re: Planning Application R/90/22/HH - 10 Fosters Close

Application No: R/90/22/HH
Site Address: Kingfishers 10 Fosters Close Rustington BN16 2TL
Description of works: Single storey side garage extension, front porch extension, hip to gable loft conversion including the installation of front dormers and rooflights and alterations to fenestration/openings.

PROPOSED EAST ELEVATION 1:100

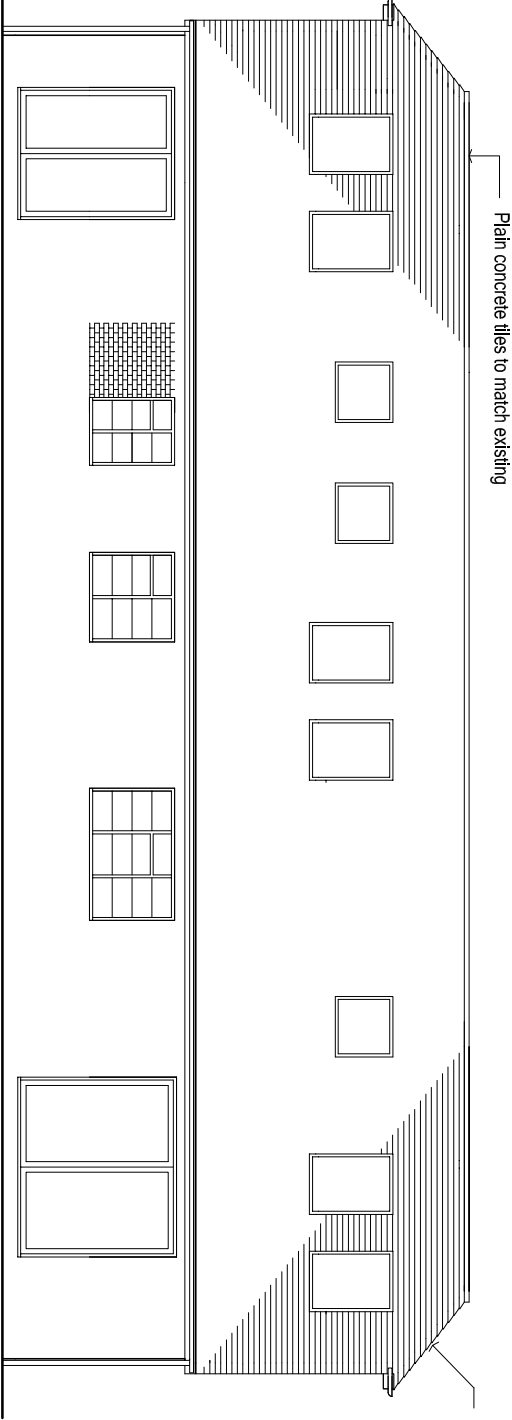
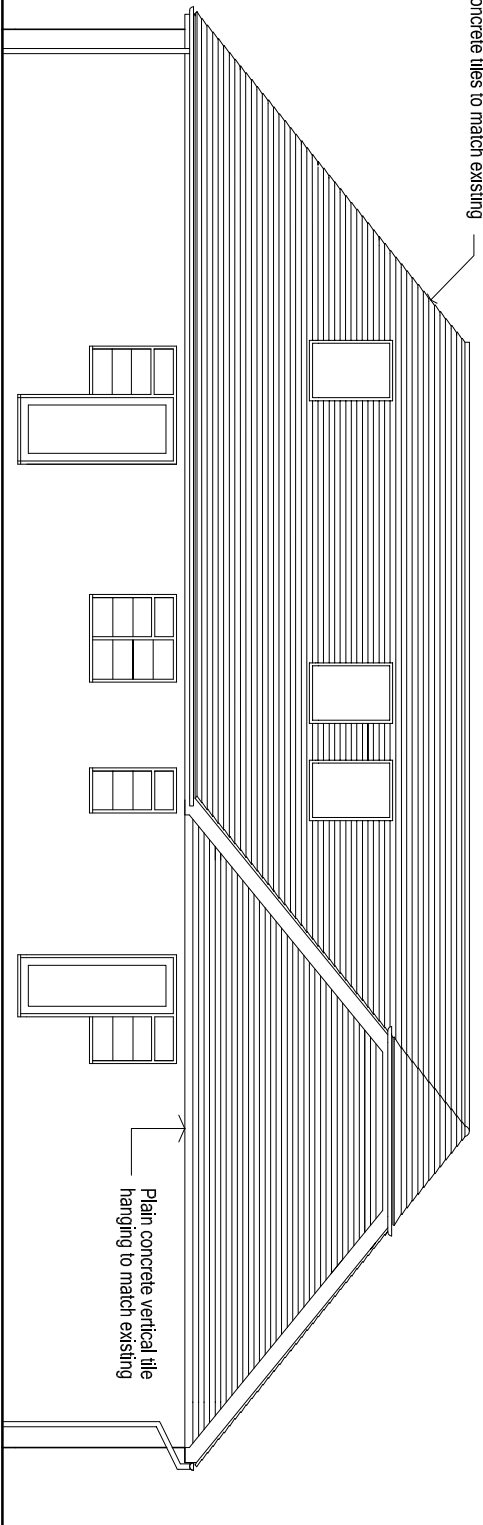
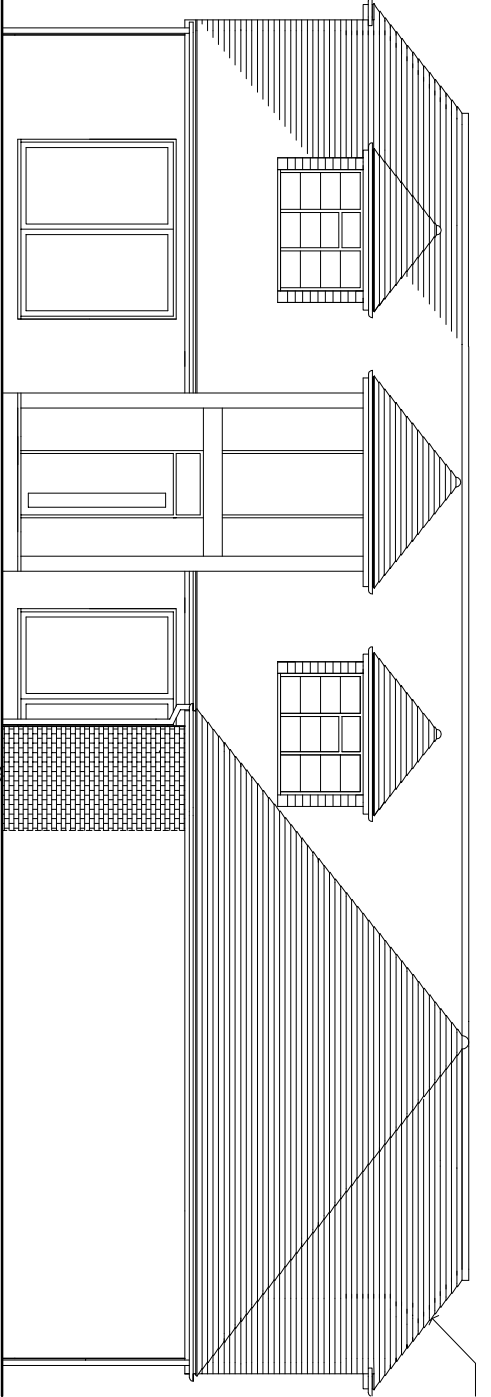
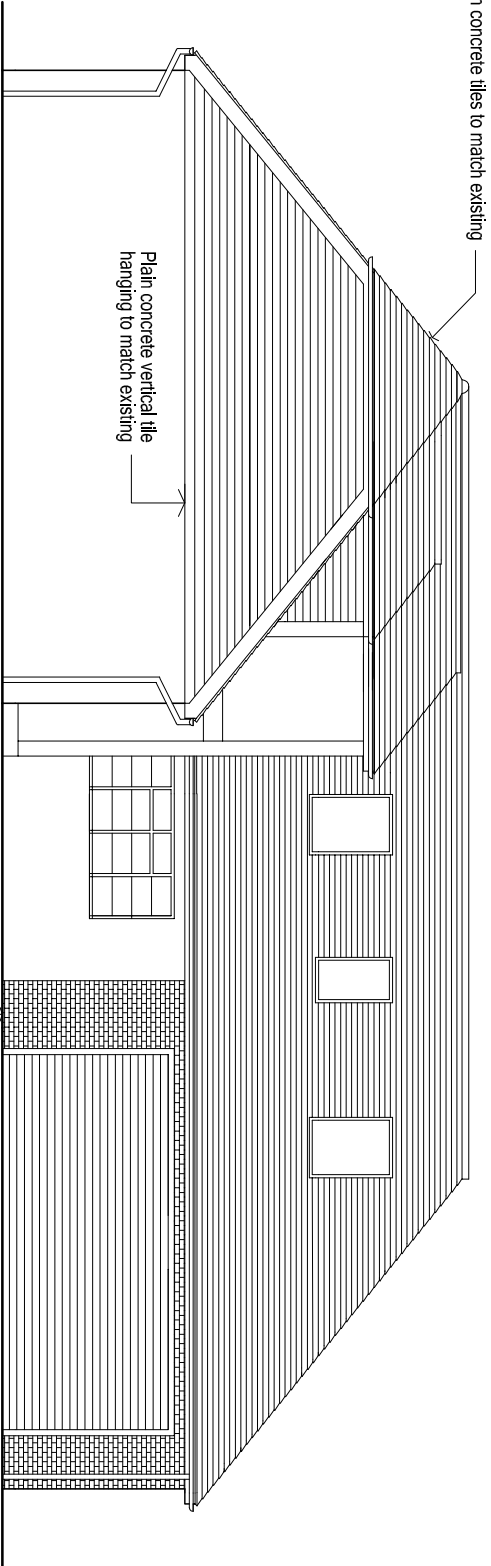
Please find enclosed photos of my house, which shows views from all of the rooms at the rear of our property, plus one from the front bedroom, all of these show the existing roof on 10 Fosters Close. The proposed new roof will be higher with three velux windows which will look directly into our house hence our objection.

We are most strongly opposed to a raised roof being constructed, the proposed roof is designed with three windows in, which when viewed through will give a very clear uninterrupted view straight into our house wiping out 90% of our privacy within, the rooms in question which privacy would be seriously compromised are our three bedrooms, landing area, bathroom & shower, the full width and depth of our lounge, Kitchen and dining area, and hallway and both balconies, plus the majority of our garden, patio and pool.

During the last 18 years of living in our house my wife and I have benefited from total privacy from all rooms at the rear of our property including our garden, patio and swimming pool. If the three proposed windows shown on the plans of the eastern roof elevation were to be permitted to be installed we would lose 90% of that privacy as the windows would look directly into our kitchen, lounge, hallway, dining area, on the ground floor, on the 1st floor would give direct view into two rear bedrooms including one a bathroom, galleried landing area across to a front bedroom and also both balconies to the rear of the house.

I see by the proposed plans that the first floor lounge and the Lego room have been designed with west facing windows, which would make the two rooms in question light and bright. Deleting the windows on the eastern side of the property would not detract from the design or aesthetic of the property, as they would be unable to be seen by anybody other than myself and my neighbours at 47 & 51 due to the fact that the rear of the property is built only 2.2 meters from my boundary.
